WEST SUSSEX COUNTY COUNCIL CONSULTATION

TO:	Arun District Council FAO: Michael Eastham
FROM:	Stephen WSCC - Highways Authority
DATE:	8 October 2019
LOCATION:	Boweries Barnham Road Chichester PO20 3RT
SUBJECT:	EG/22/19/OUT Outline application with some matters reserved for the erection of 28 No. dwellings, access, landscaping & associated works (resubmission following EG/42/18/OUT). Various amended plans received.
DATE OF SITE VISIT:	
RECOMMENDATION:	Advice / Further Information
S106 CONTRIBUTION TOTAL:

client			
Domusea Limited			
project			
The Boweries Barnham Road Eastergate			
title			
Wider Development and Landscape Framework Plan			
date	scale @ A3	drawn	chkd
Jan 2019	1:1500	MRL	GBC
project no.	drawing no.	rev	
1815	1000	P01

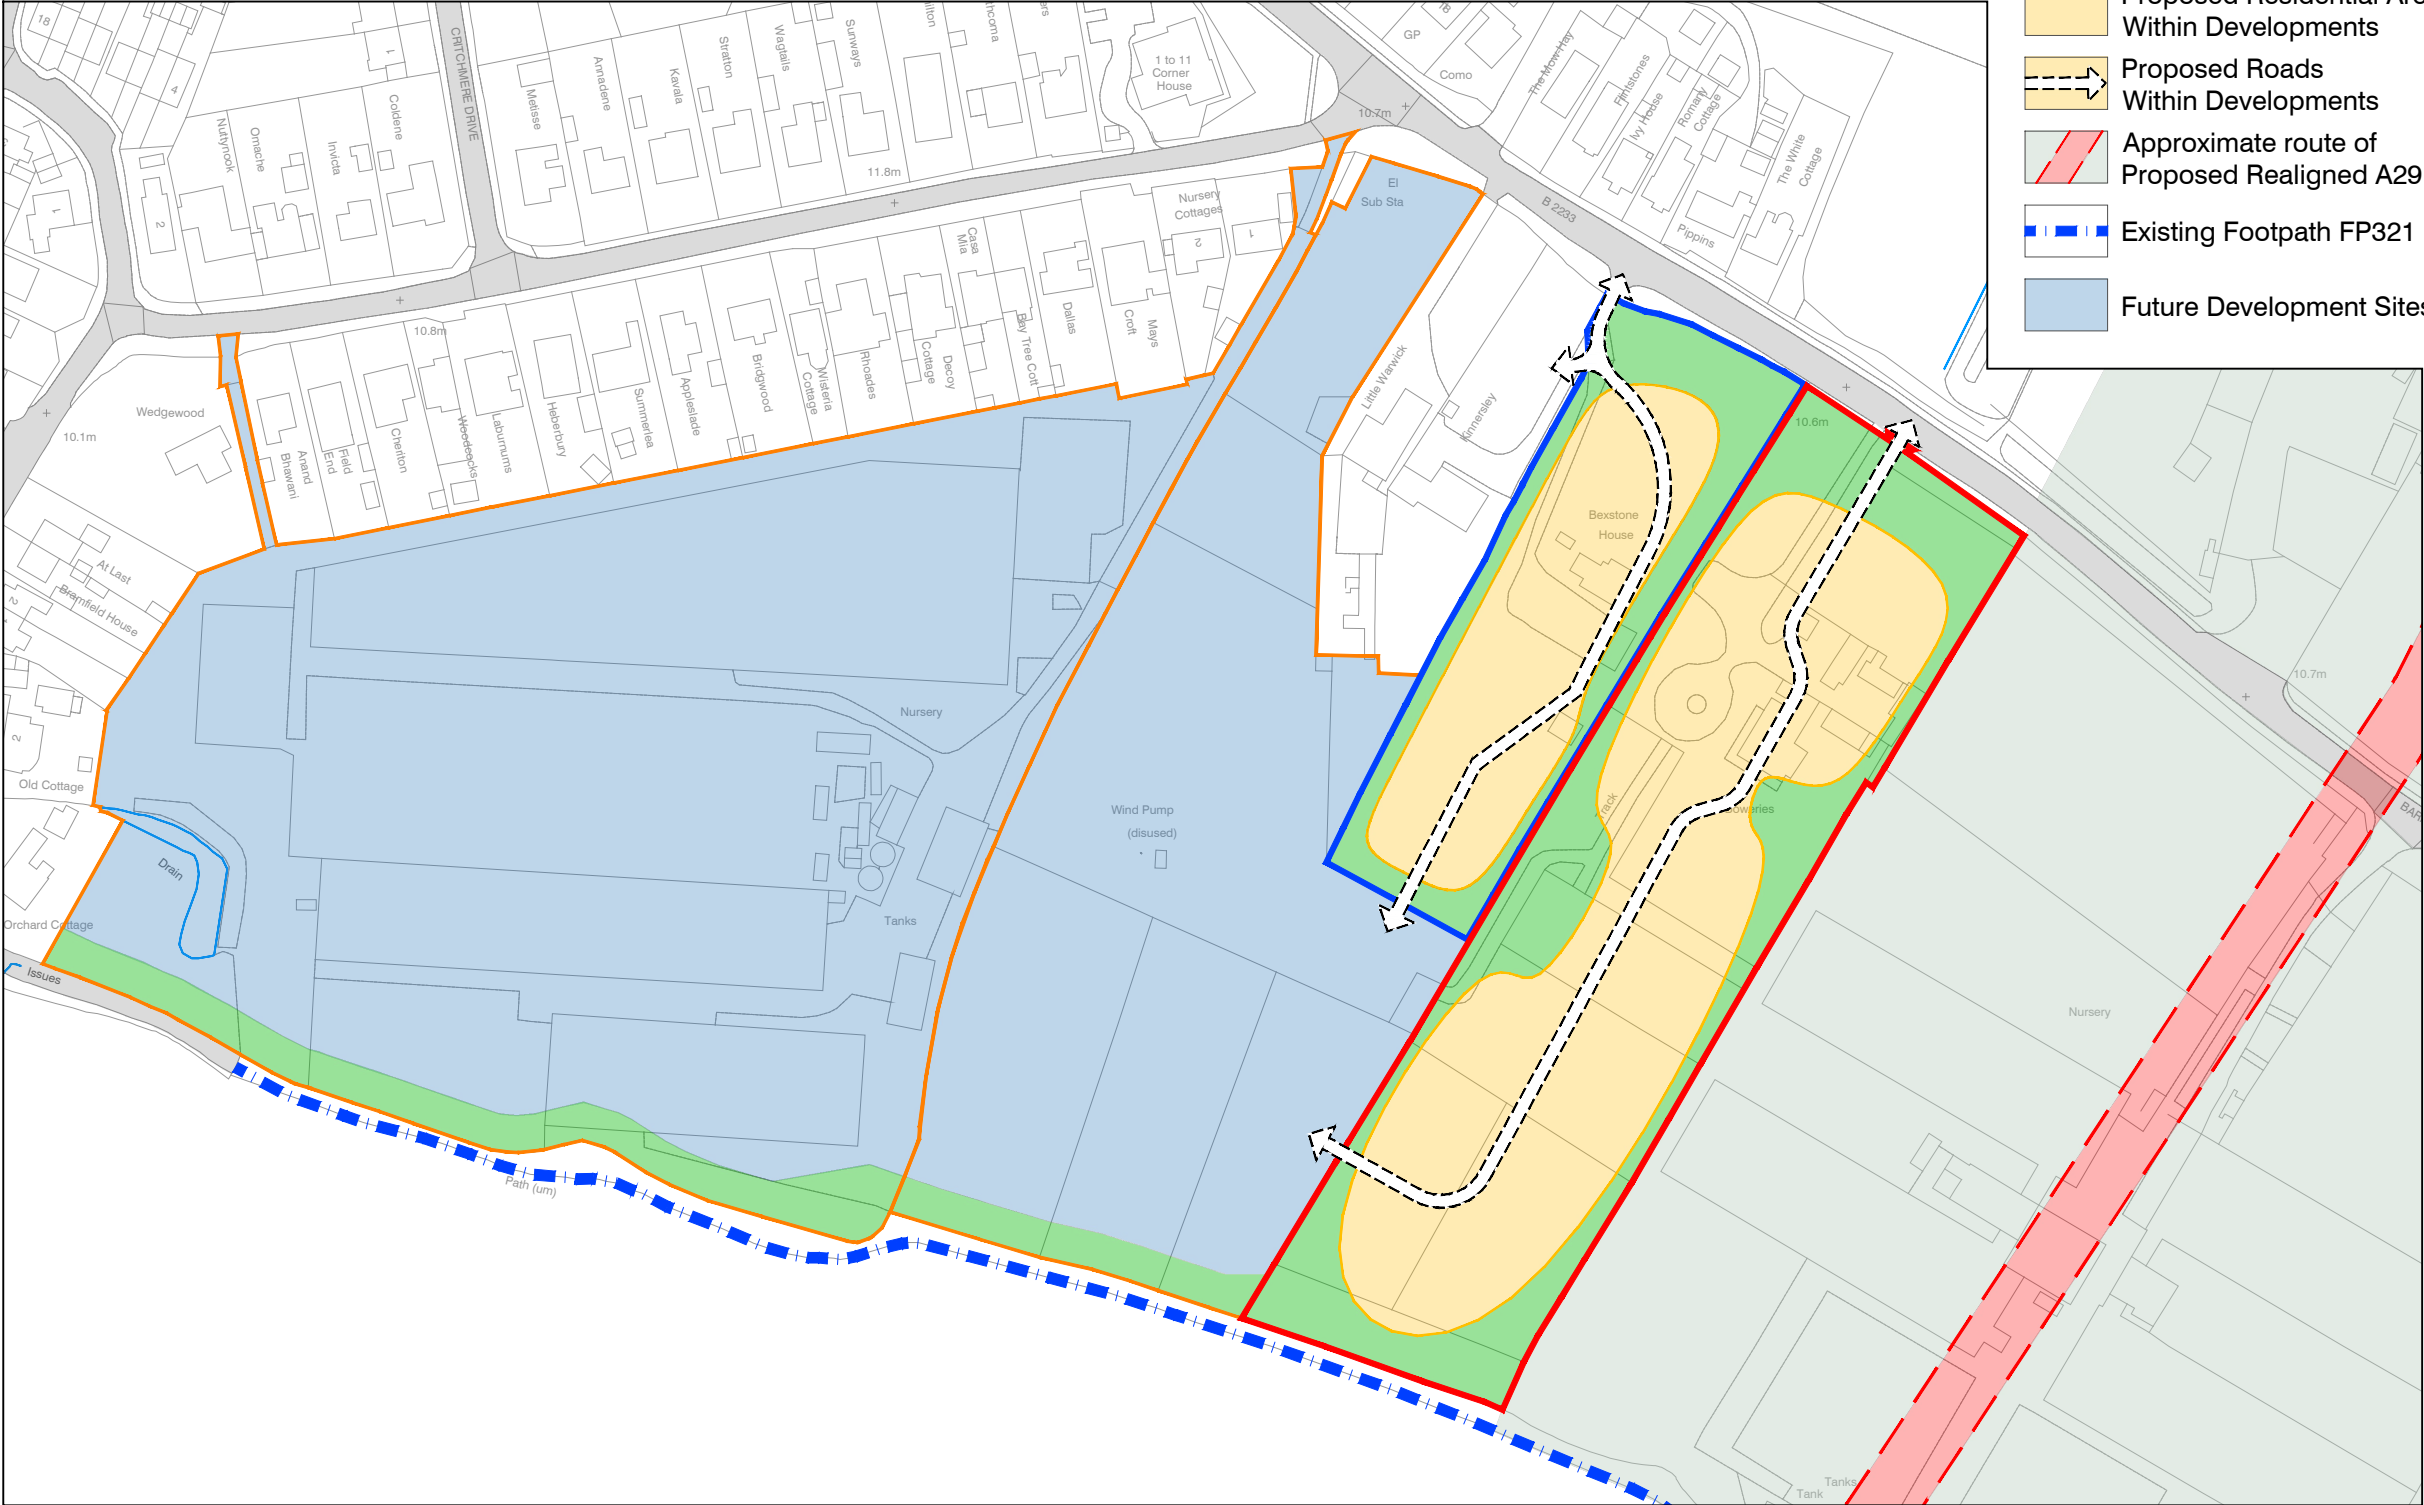
- the site would benefit from pedestrian/ cycle access to the south;
- the wider development ands landscape framework shows links that would not be facilitated by the proposed site layout;
